Further assessment of trees adjacent to the A3 boundary

RHS Wisley, Surrey

J2002 - M25 J10 DCO further tree assessment

2nd July 2020

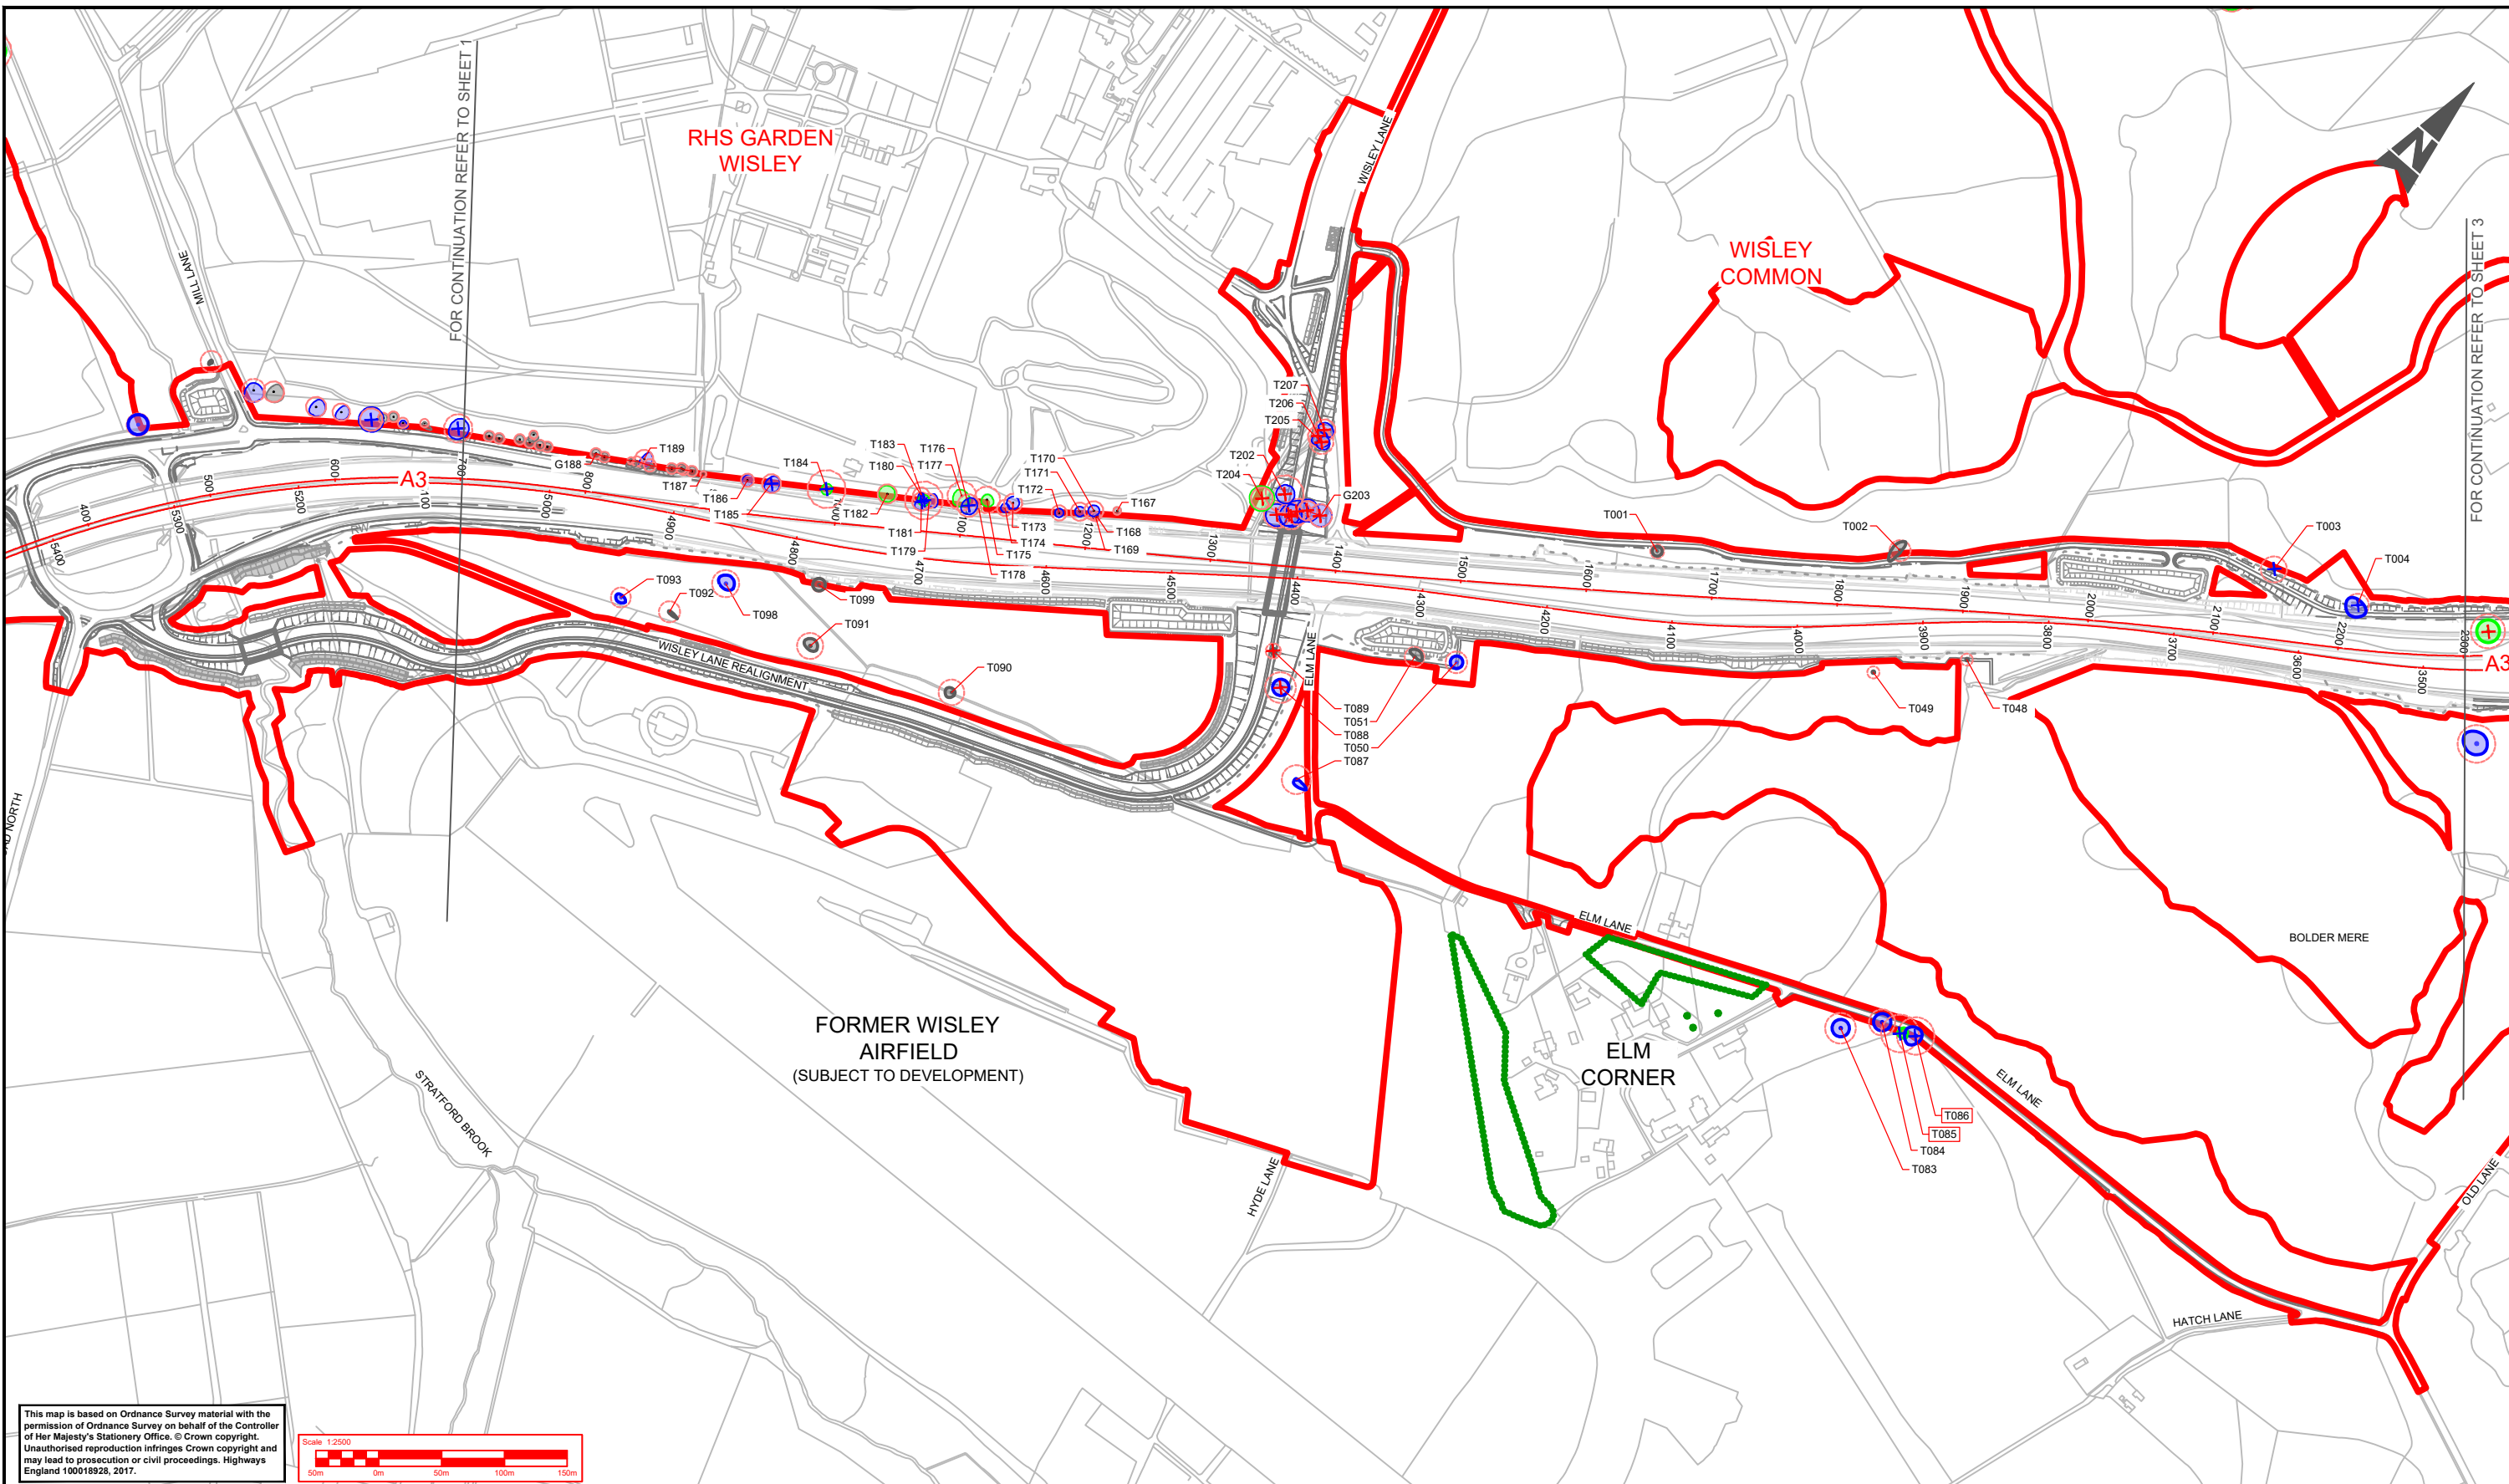
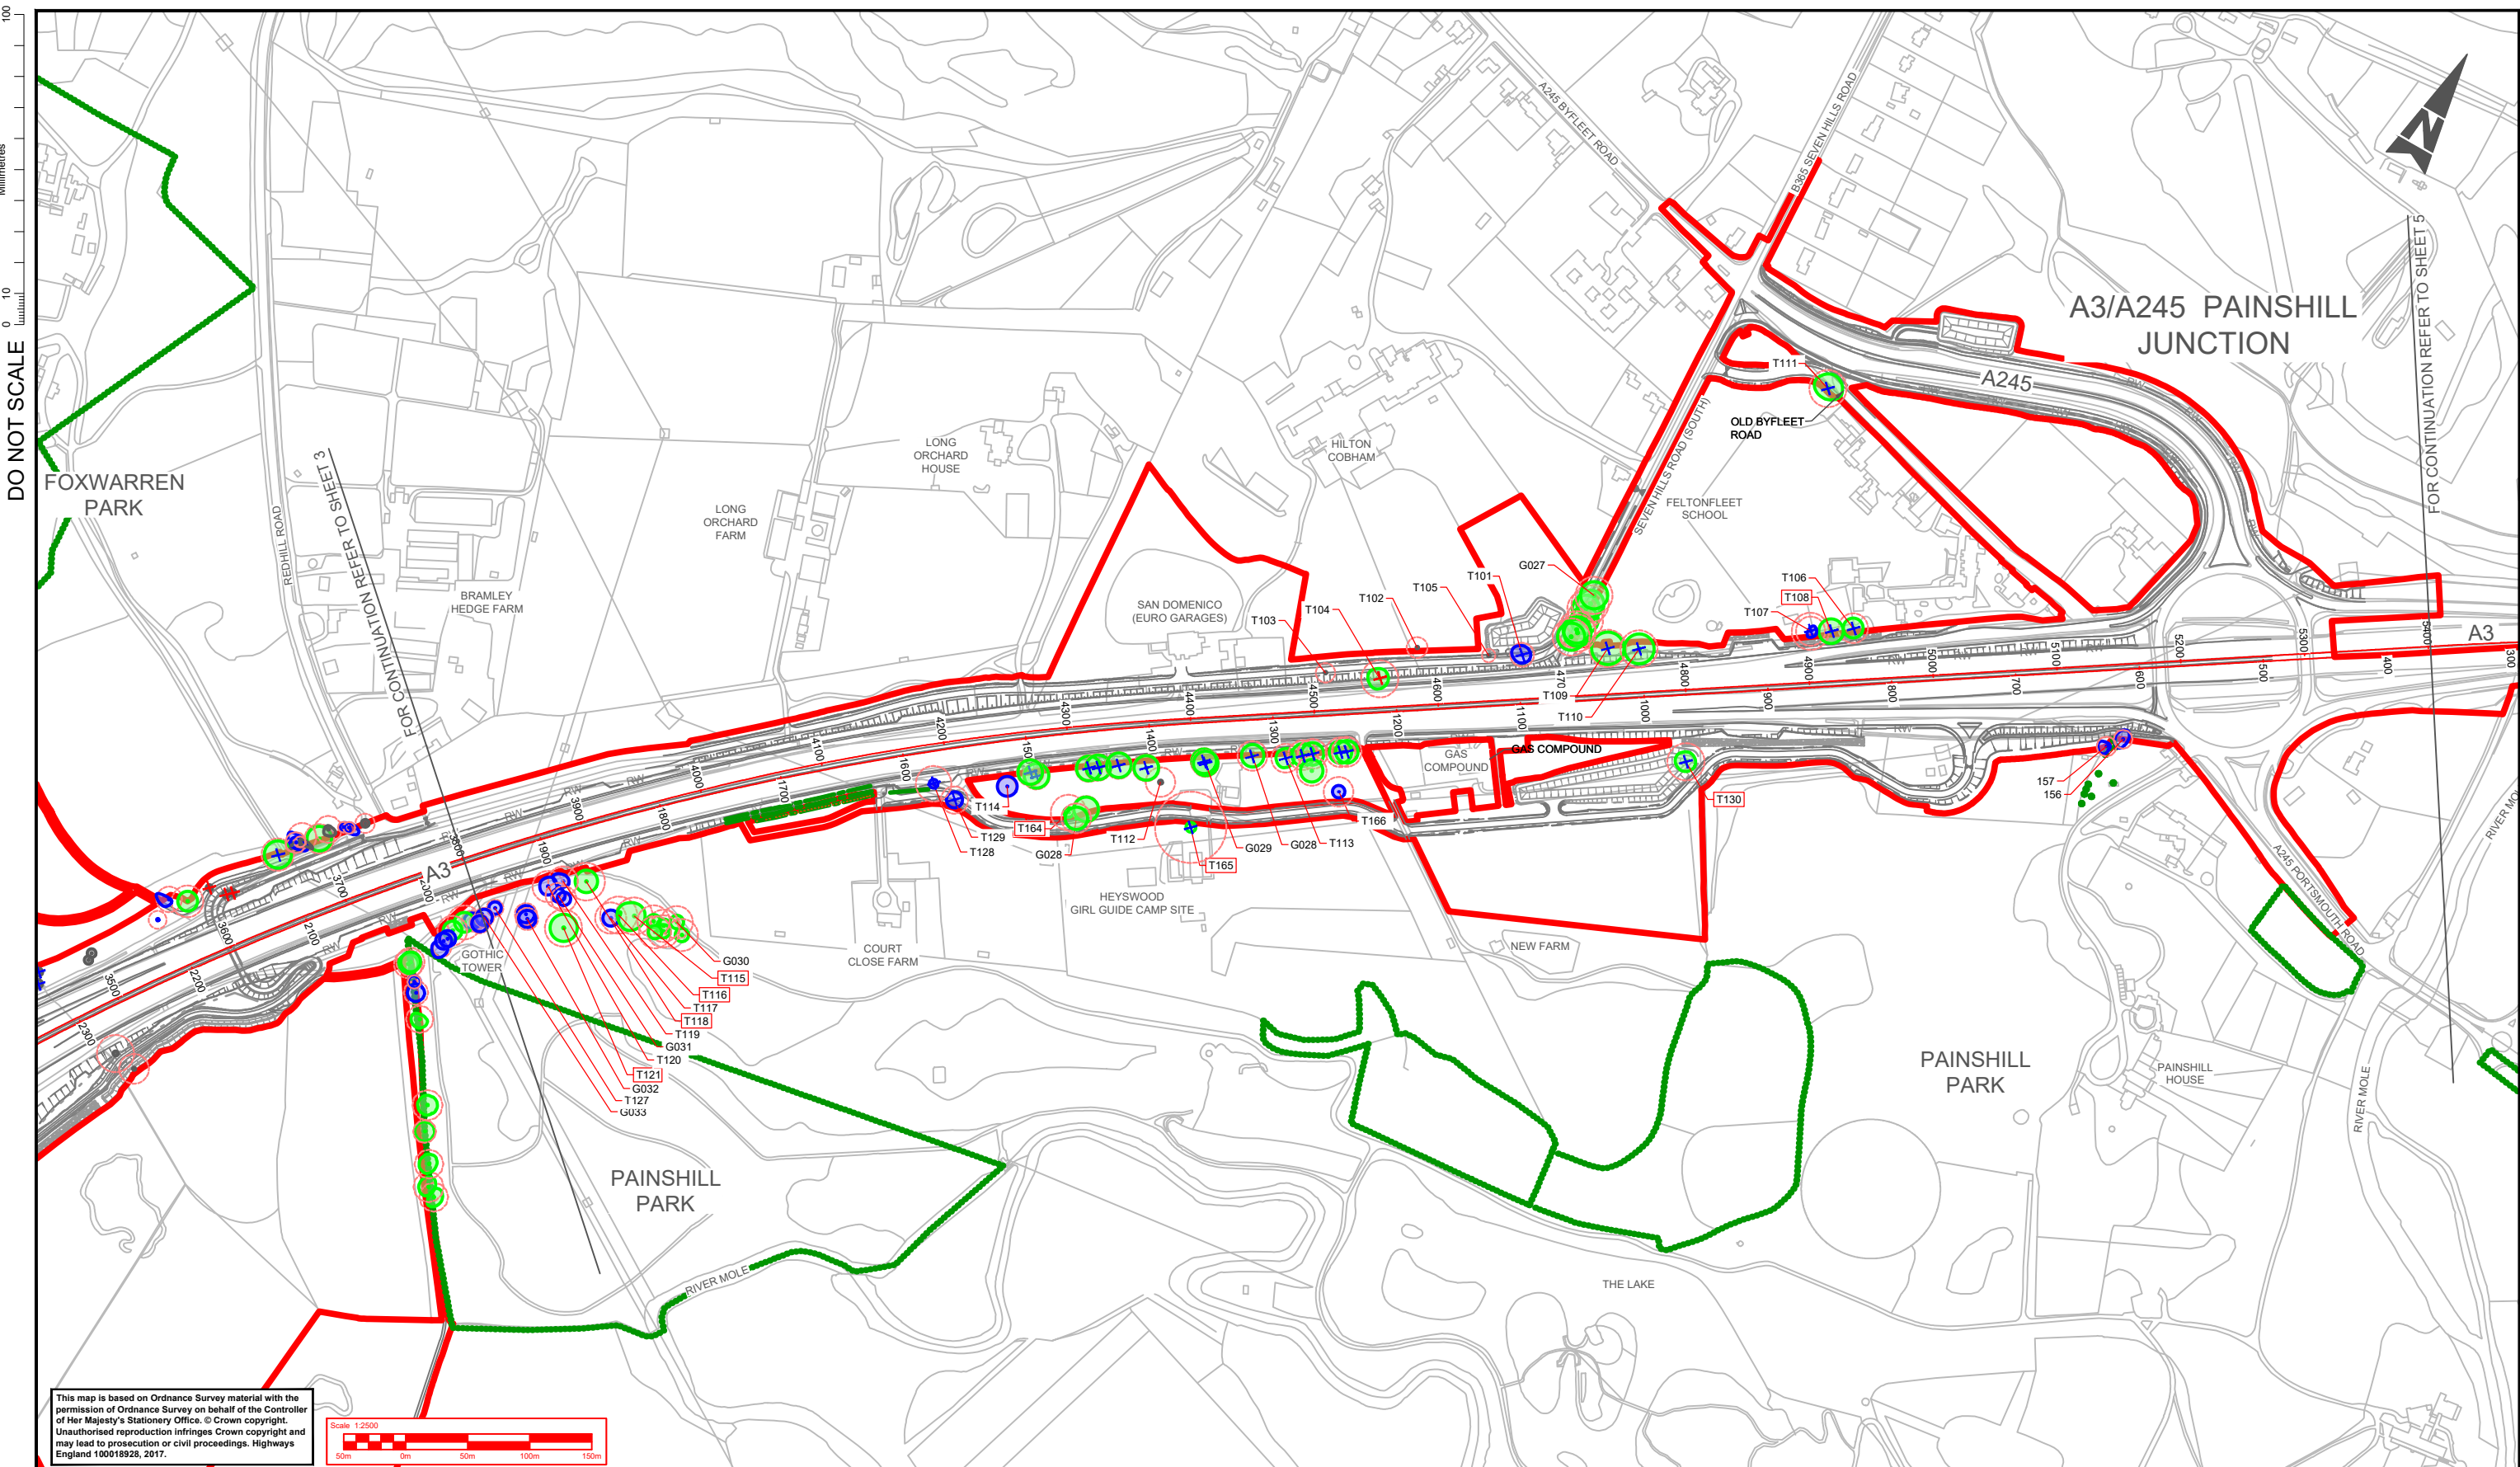
From my review of the HE survey and comparing it to the 44 trees that I identified as being at risk, I found that the HE survey failed to:

1. take any account of the heritage or financial value of any of the Wisley trees that could be adversely affected;
2. to follow the guidance in BS 5837 on respecting RPAs;
3. to identify 16 trees (1, 2, 4–17) as impacted through the Wisley Lane changes; and,
4. possibly account for a further 15 trees (18–22, 24, 29, 31–33, 35, 37, 40–42) that could be adversely affected and may also have been missed from the HE survey.

I concluded that my plan BT1 in Appendix 1 is a reliable record of trees that could be affected, whereas the HE survey is demonstrably not.

From my assessment in my report of 17th April 2020 (Let1-170420-JB), HE has not taken any account of the heritage or financial value of any of the Wisley trees that could be adversely affected. Furthermore, that assessment failed to follow the guidance in BS 5837 on respecting RPAs, and it certainly failed to identify 16 trees (1, 2, 4–17) as impacted through the Wisley Lane changes. Additionally, because of lack of clarity in the HE data allowing a positive identification, there is also possibly up to a further 15 trees (18–22, 24, 29, 31–33, 35, 37, 40–42) that could be adversely affected and may also have been missed from the HE survey.

In summary, plan BT1 in Appendix 1 is a reliable record of trees that could be affected, whereas the HE survey is demonstrably not.
